Recommendation Report for Planning Permission for Works or Extension to a Dwelling

REF NO: AW/47/18/HH

LOCATION: 5 Larchfield Close
Aldwick
PO21 4RB

PROPOSAL: Single story rear extension (re-submission of AW/223/17/HH). This application may affect the character & appearance of the Craigweil House Conservation Area.

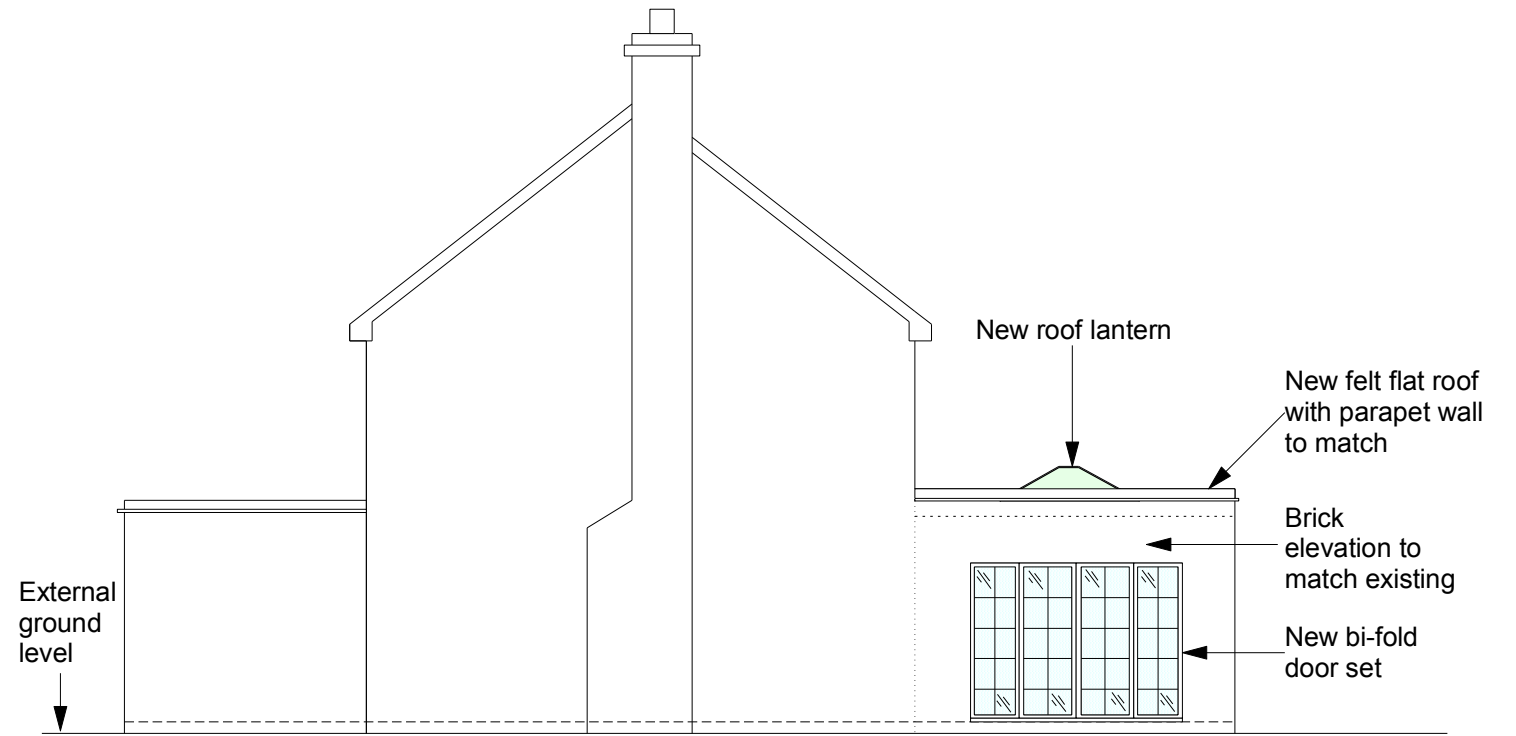
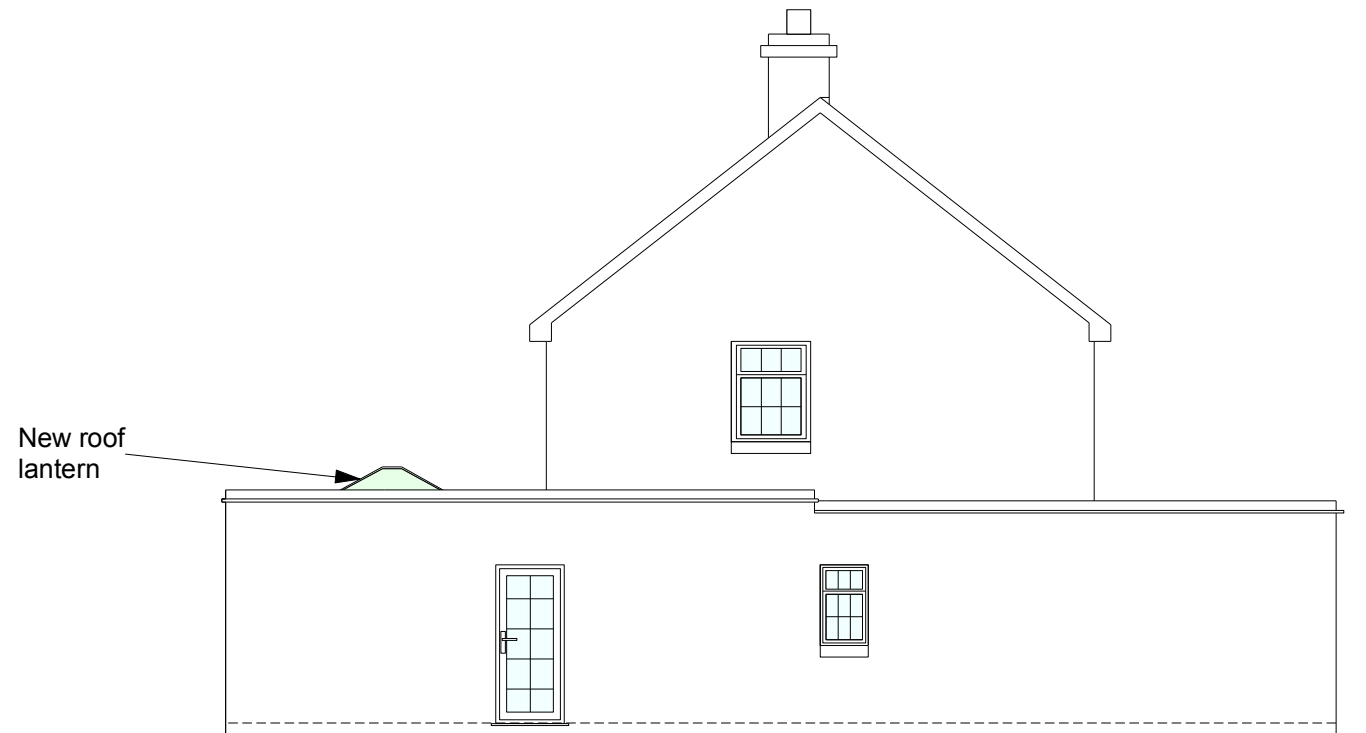
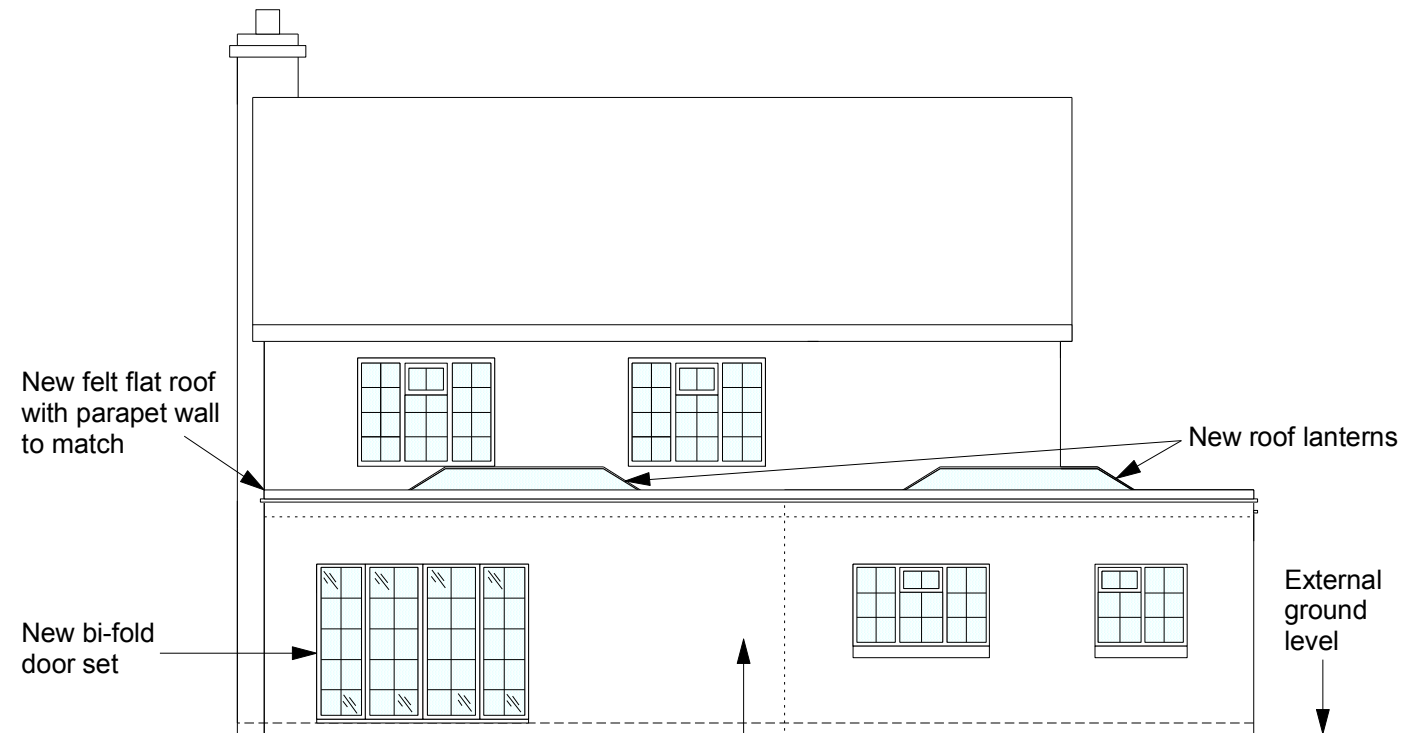
The proposed extension is situated to the rear of the property. Whilst the extension is unlikely to be visible from the street scene, it may be possible to see glimpses of the top of the roof lantern however the impact on the street scene is considered minor.

The proposed rear extension will match in materials to that of the existing property and will match in size to an existing flat roof extension to the rear, therefore it is considered to be well integrated and subservient to the main dwelling.

The proposed extension will be sited only slightly larger than what currently exists at around 0.4m larger in depth and no extra overall height. The proposed extension will install two sets of glass doors to the south and east elevation and 2 sets of roof lanterns. The glass doors to the east will overlook the rear garden whilst the doors to the south will overlook some of the garden and fencing at the boundary. The extension is set around 4.5m away from the southern boundary fence and given the location and height of the proposed extension it is not considered to give rise to any harm to the adjoining occupiers due to loss of privacy or outlook.
